Awel y Môr Offshore Wind Farm

Planning Inspectorate reference:
EN010112

Summary of Written Representation
for Examination Deadline 1 by
Gwynedd Archaeological Planning Service

24th October 2022

Drawing file: EN010112 / EN010112-000411-6.6.10.5.48_AyM_SLVIA_Fig_75a-c_VP52_Pen-y-Dinas_Camp_at_interpretation_sign.pdf

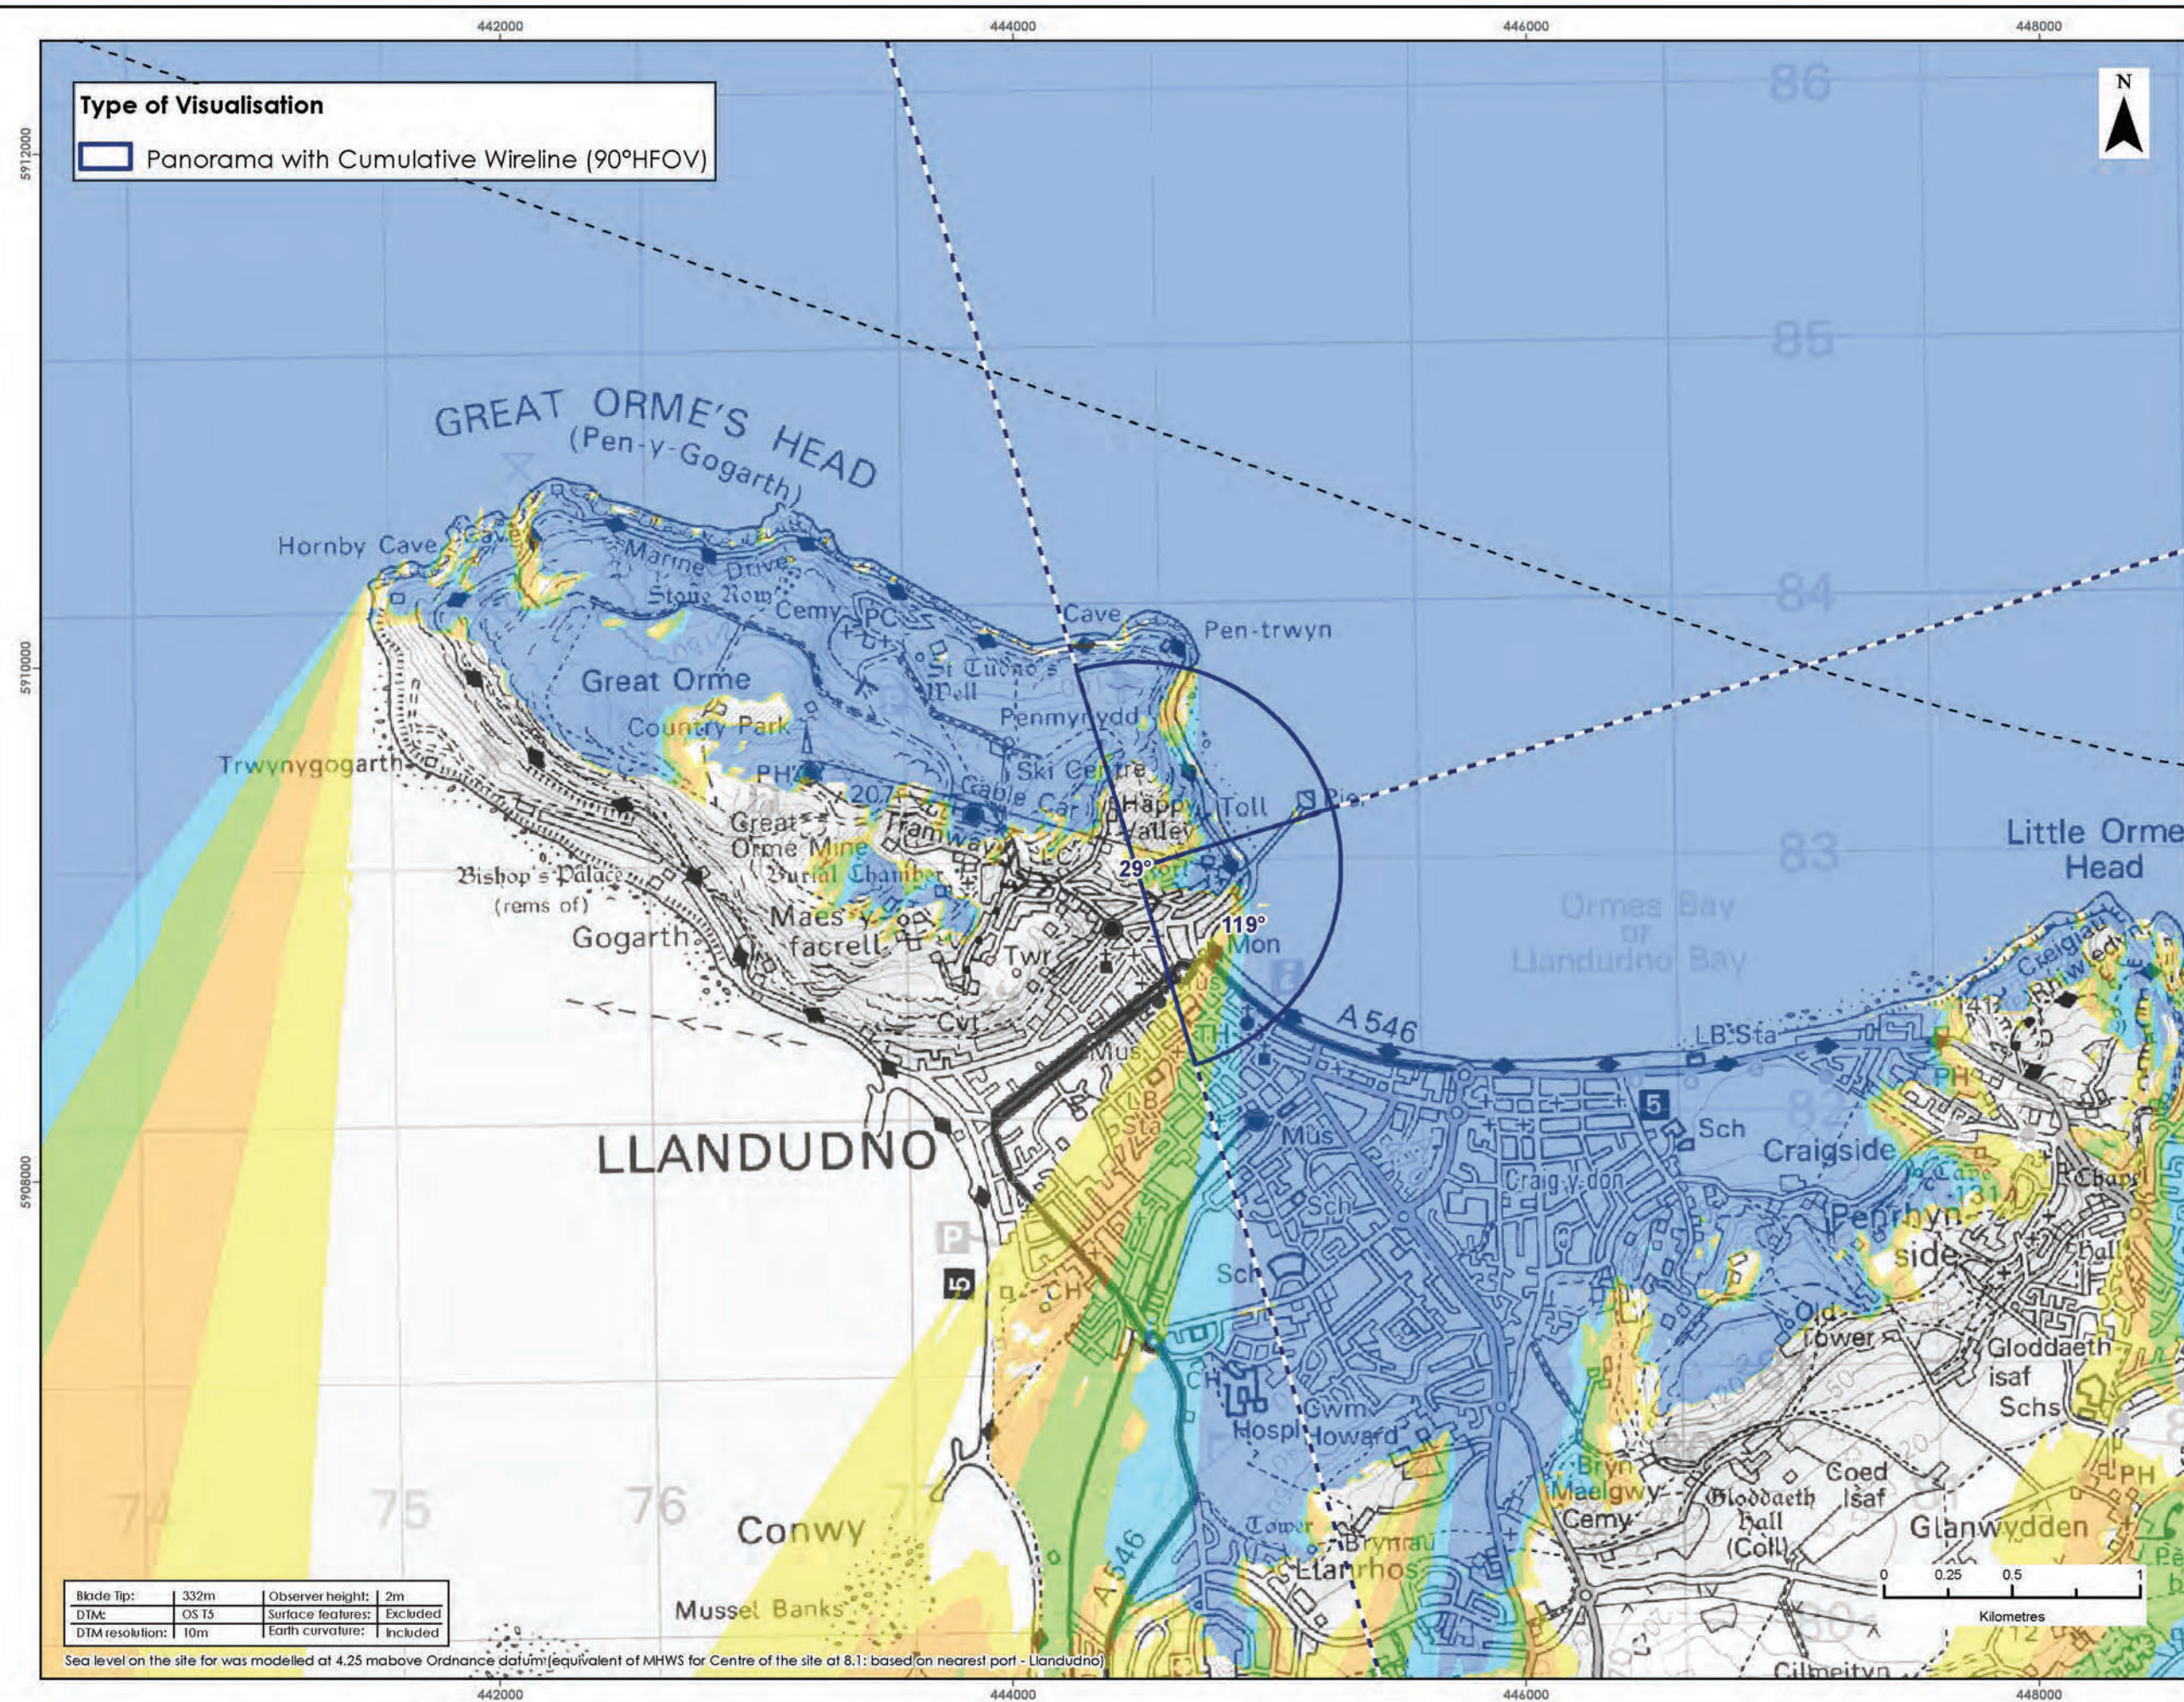
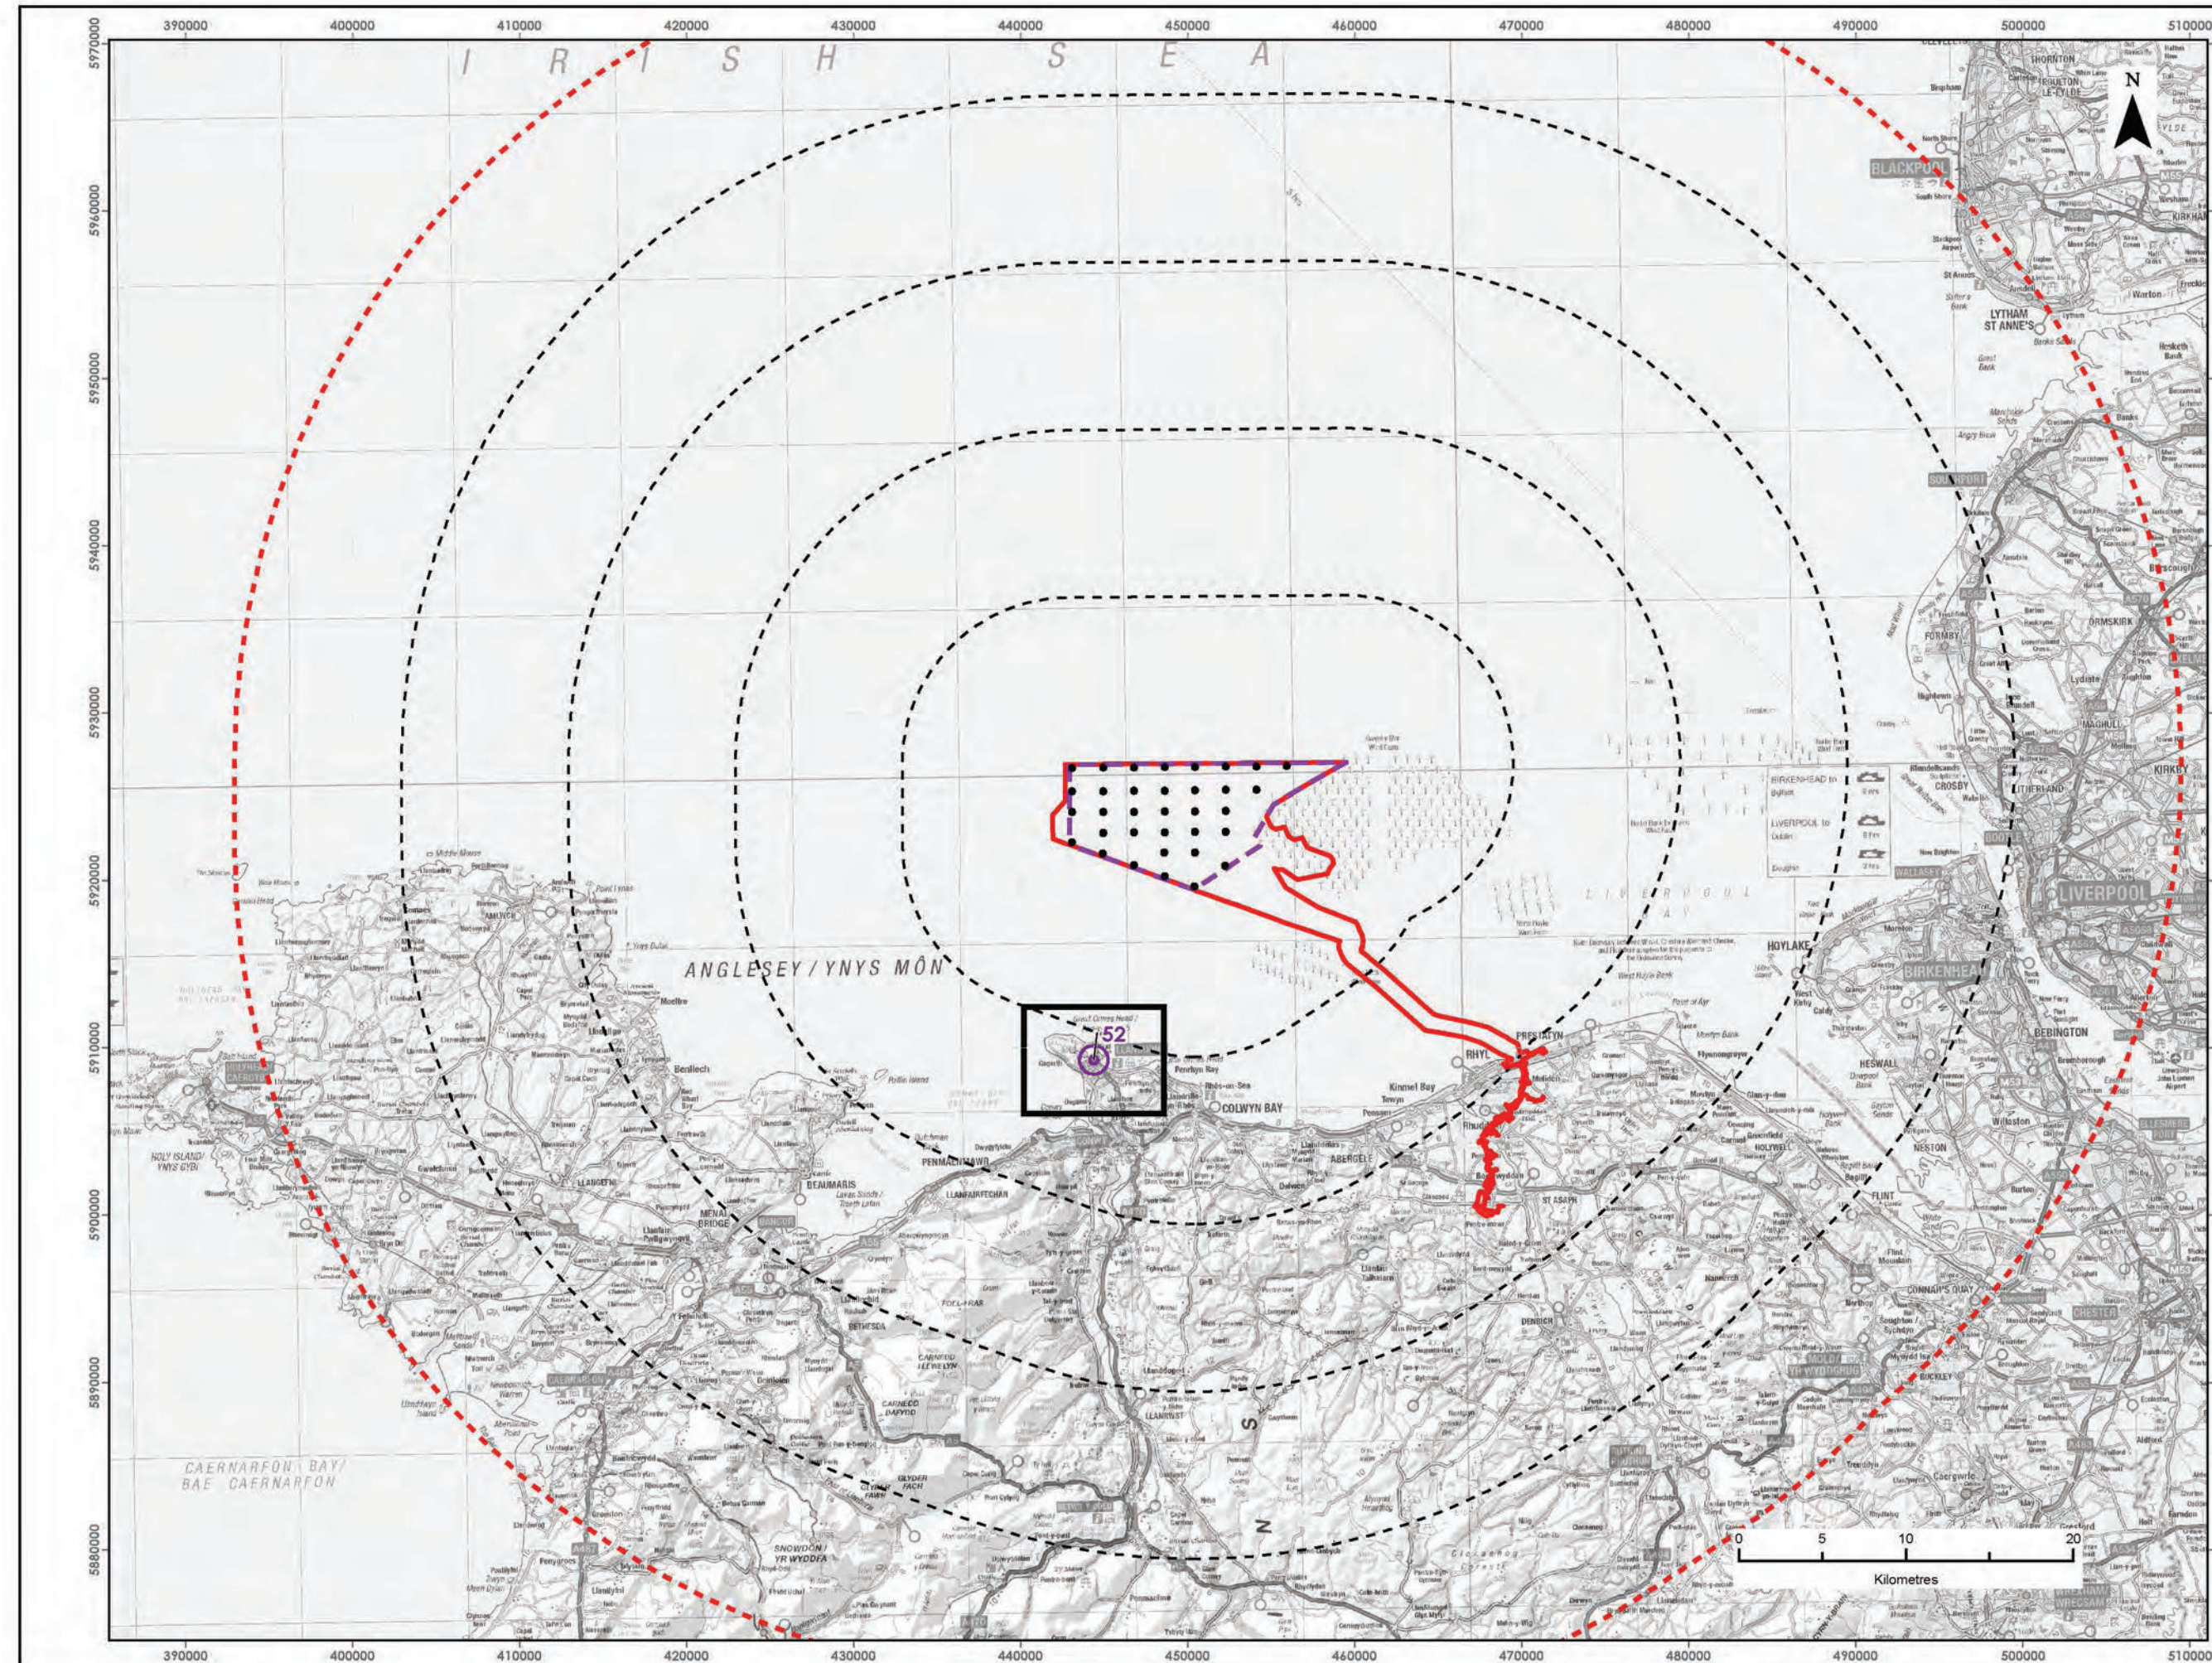
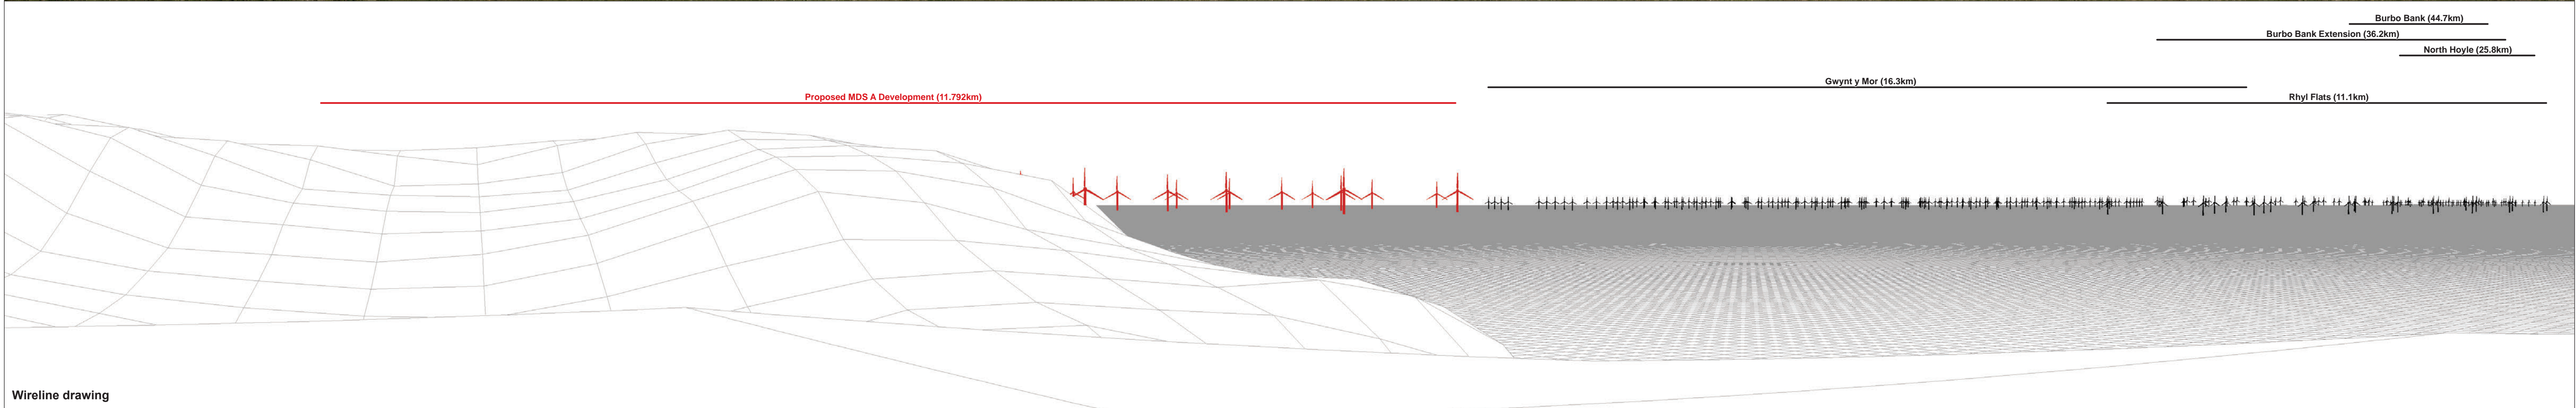
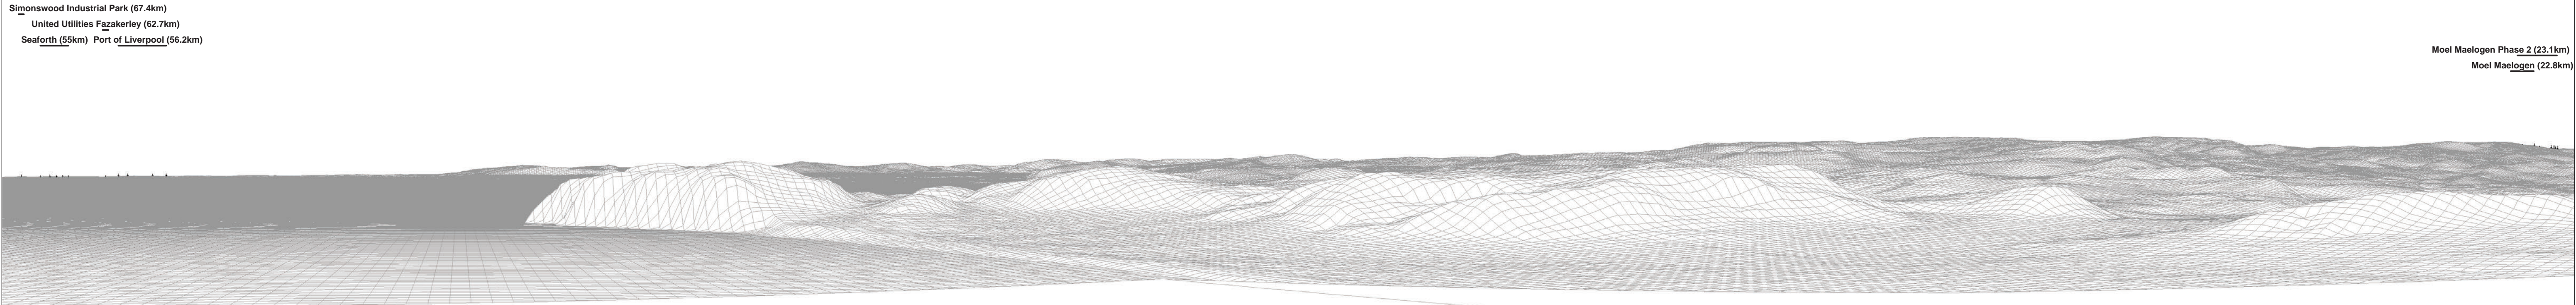
- 2.36 Whilst noting the influence of existing modern development (including offshore wind farms) within the setting of the hillfort, the assessment does not consider the cumulative impact of additional, larger wind turbines. VP52 (Volume 6, Annex 10.5, Fig. 75b) demonstrates that these would fill the current gap between existing offshore wind farms and the Great Orme headland and that, due to the difference in size, this change would be noticeable. It is also possible that appreciation of the strategic position of the hillfort from long-range views may be impeded (for example in VP12 from Conwy Mountain, Volume 6, Annex 10.5, Fig.39, where the turbines would overshadow the headland). However, the monument does not have a strong landscape expression at distance and it is difficult to argue that this has an appreciable detrimental effect on the significance of the monument or its setting. The assessment of negligible impact is therefore agreed.
